**RE: APS Family School East Side
3303 Monroe Street NE
Request for Permanent C.O. – Not Accepted
Request for 30 Day Temporary C.O. – Accepted
Building Permits – 2016-00835
Engineer's Certification Dated 11/02/17
Hydrology File: G17D019A**

Based on the Certification received 11/02/17 and site visit on 11/02/17, the site **is not** acceptable for a Permanent Certificate of Occupancy by Hydrology. The site is acceptable for a 30 day Temporary Certificate of Occupancy by Hydrology. The following comments need to be addressed for acceptance for Permanent C.O. of the above referenced project:

SITE DRAINAGE PLAN

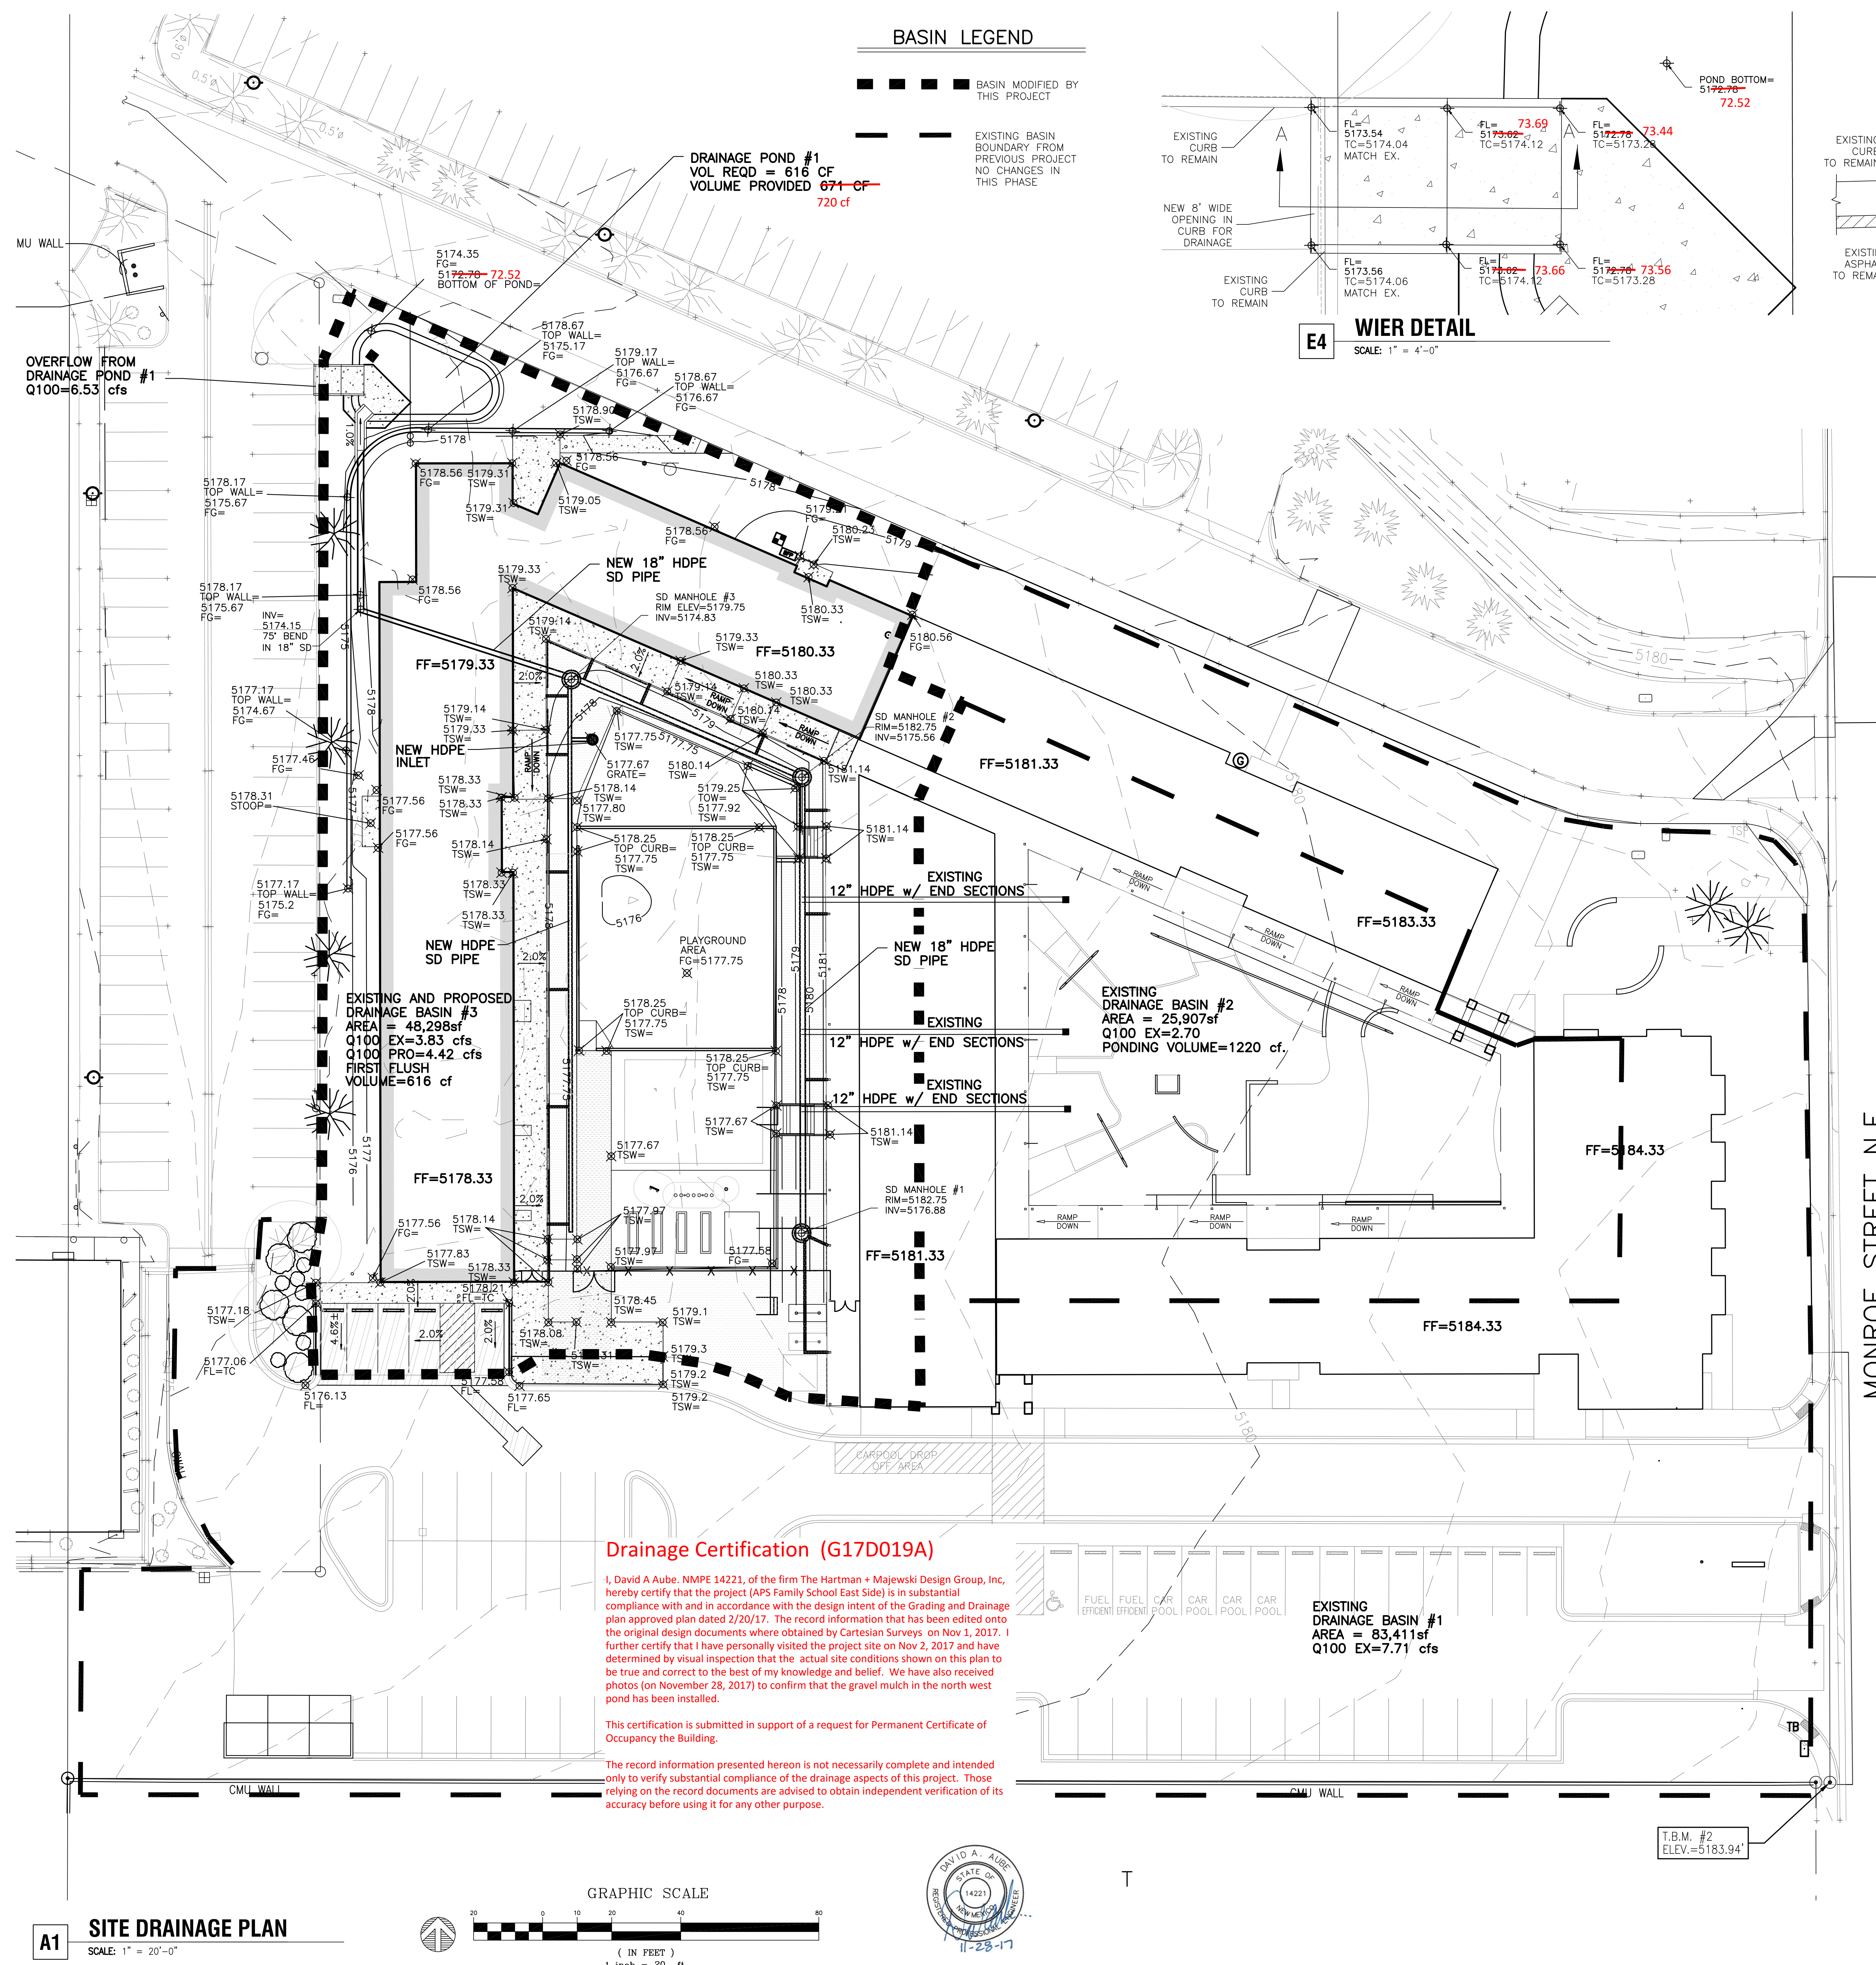
1. The Drainage Pond #1 still needs rock along the bottom of the pond. The contractor informed me that the school's landscaper was planning on installing a block wall along the steep slope of the south side of the pond. Before he makes any change to the approved Grading and Drainage Plan, a **resubmittal to Hydrology** will need to be done and once we approve the changes, then the work can be done on the pond.
